3030 St. Joseph Avenue | Formal Review | Minor Zoning Amendment | Orleans Heights Development (Torgan Group); Fotenn Planning + Design; rla Architecture.

WEST ELEVATION

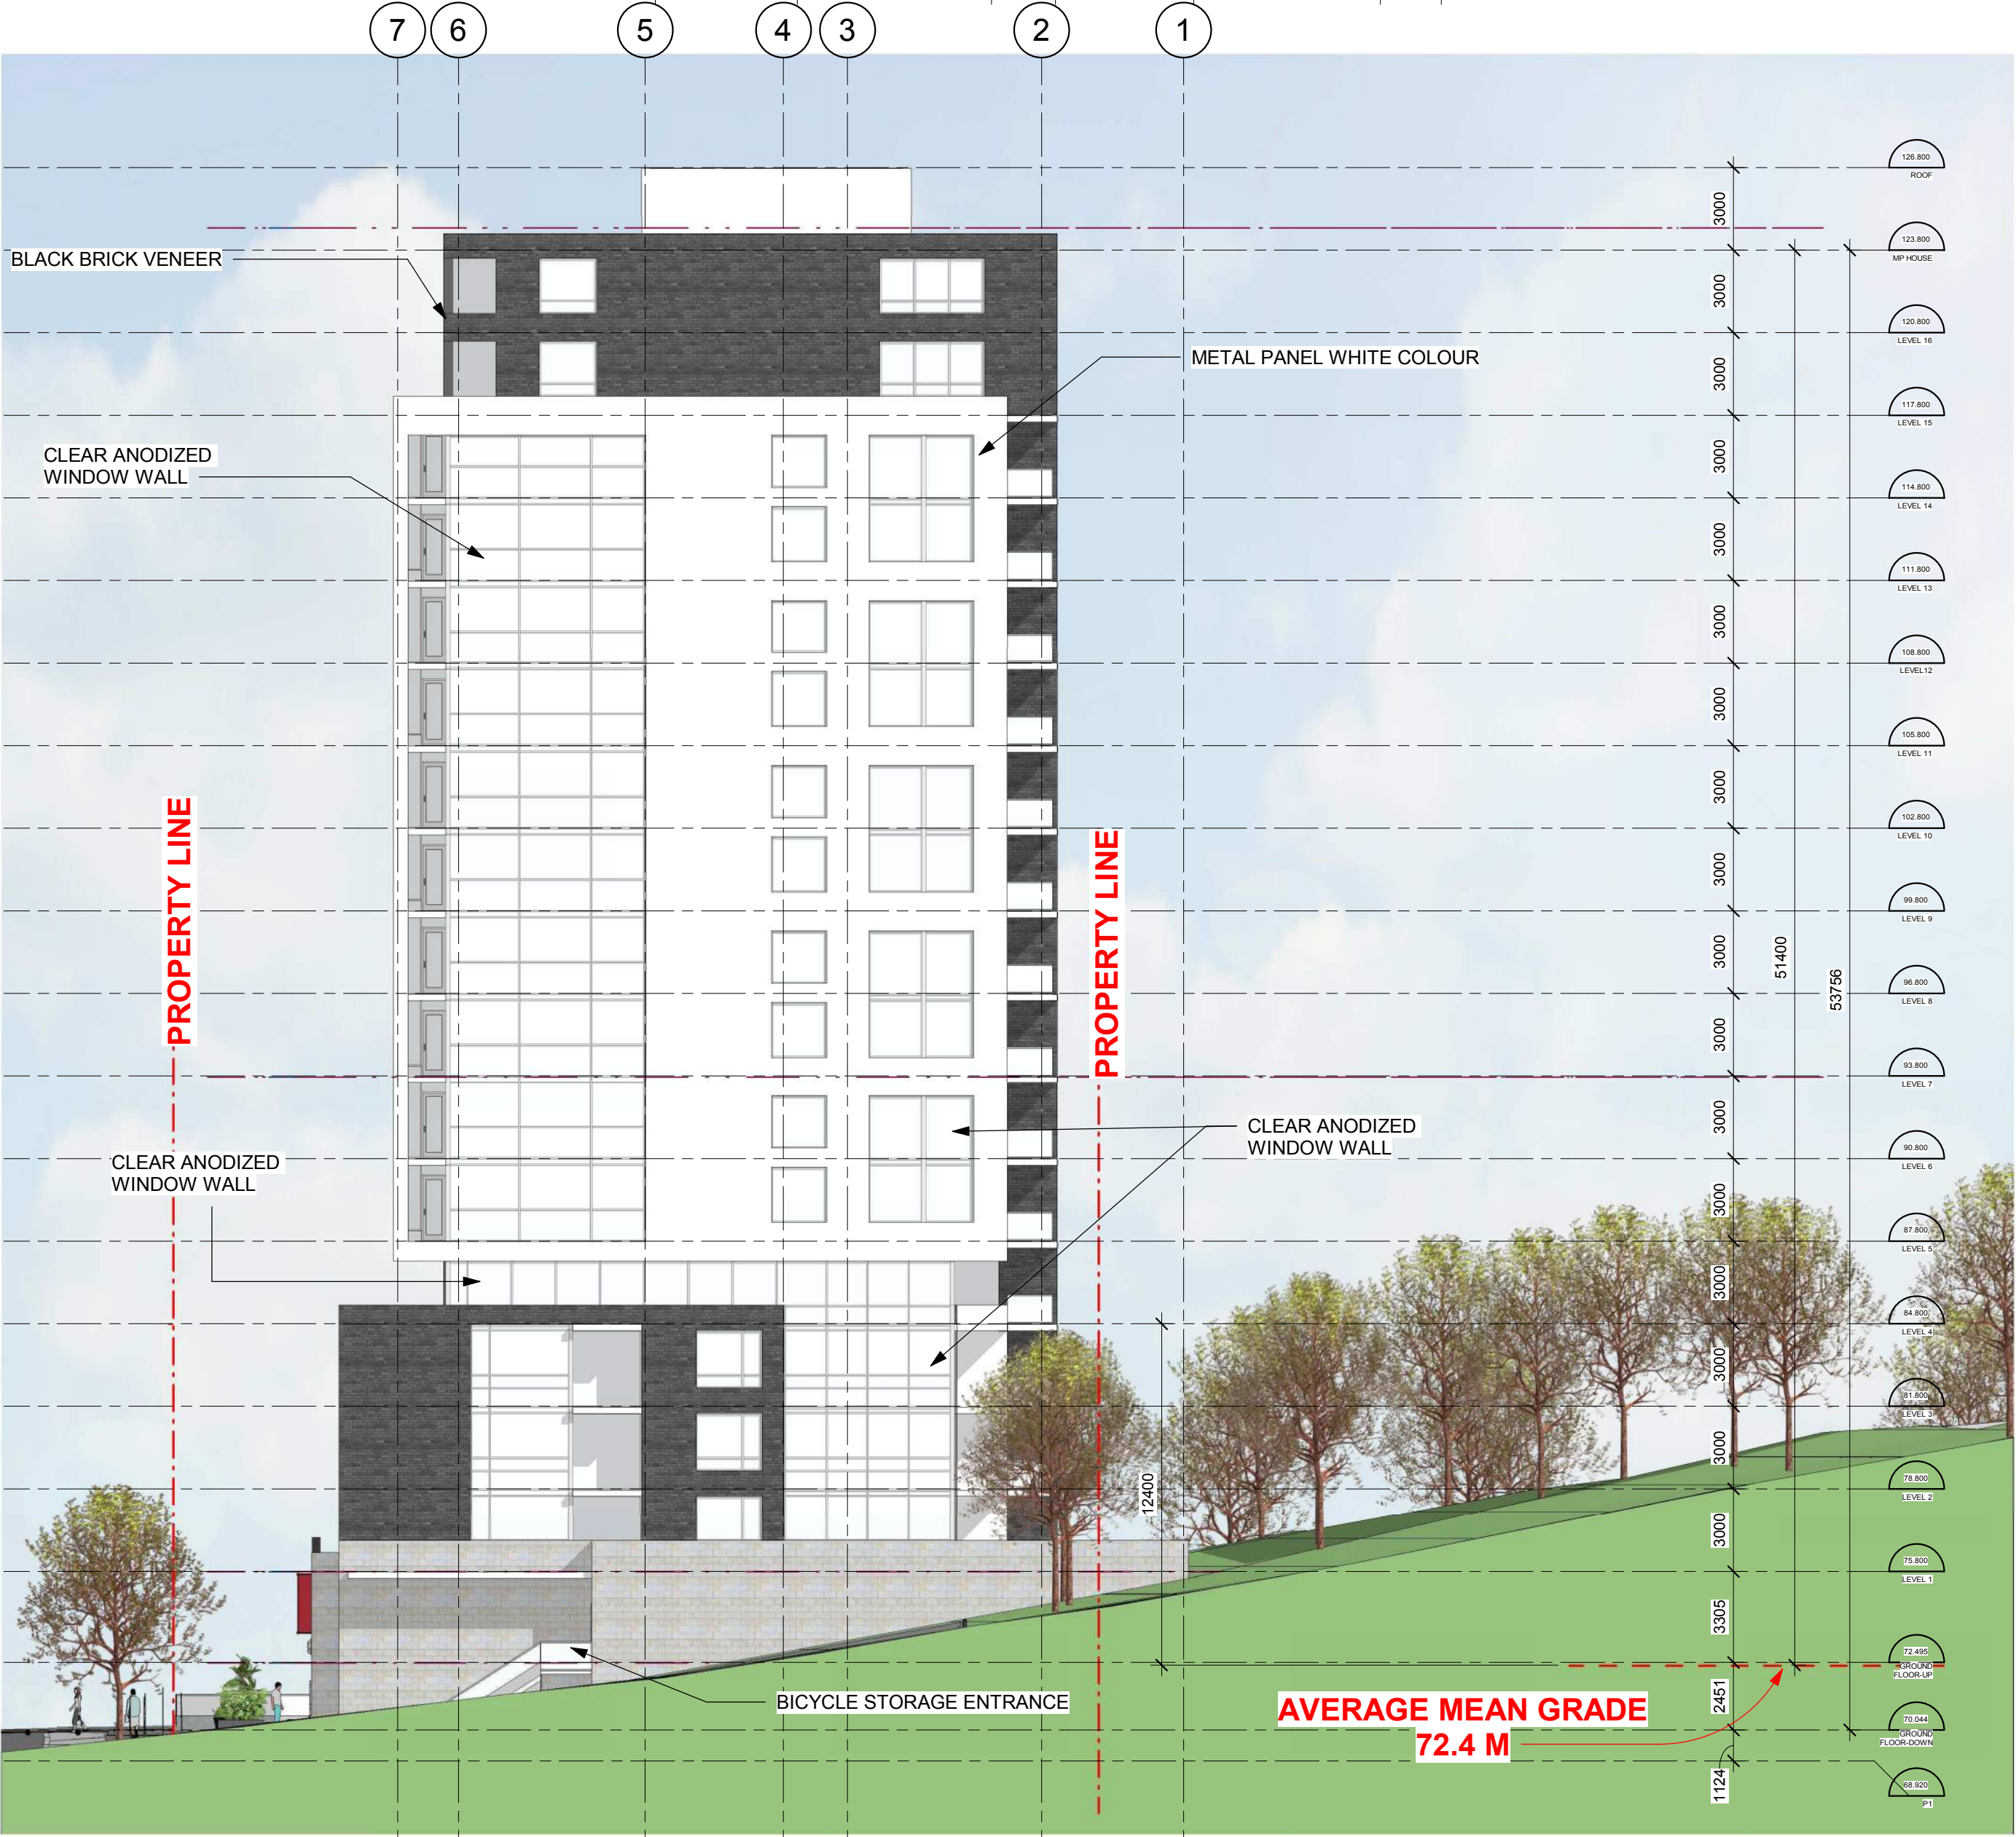
- When considering the top floor amenity, and the St. Joseph Boulevard elevation, the Panel sees this as a 14-storey building. It is the opinion of the Panel that the proposal represents overbuilding of the site, and recommends that eight stories is the maximum height in order for the building to fit its context at the edge of a low-density residential neighbourhood.
- The Panel suggests that the tower portion of the building fronts St. Joseph Boulevard, with a lower podium located along Duford Drive, thereby shifting density away from the residential side of the lot. The current distribution of massing results in an imposition to the established residential area to the south.
- The Panel suggests that the corner element of the building could be redesigned to be more slender.
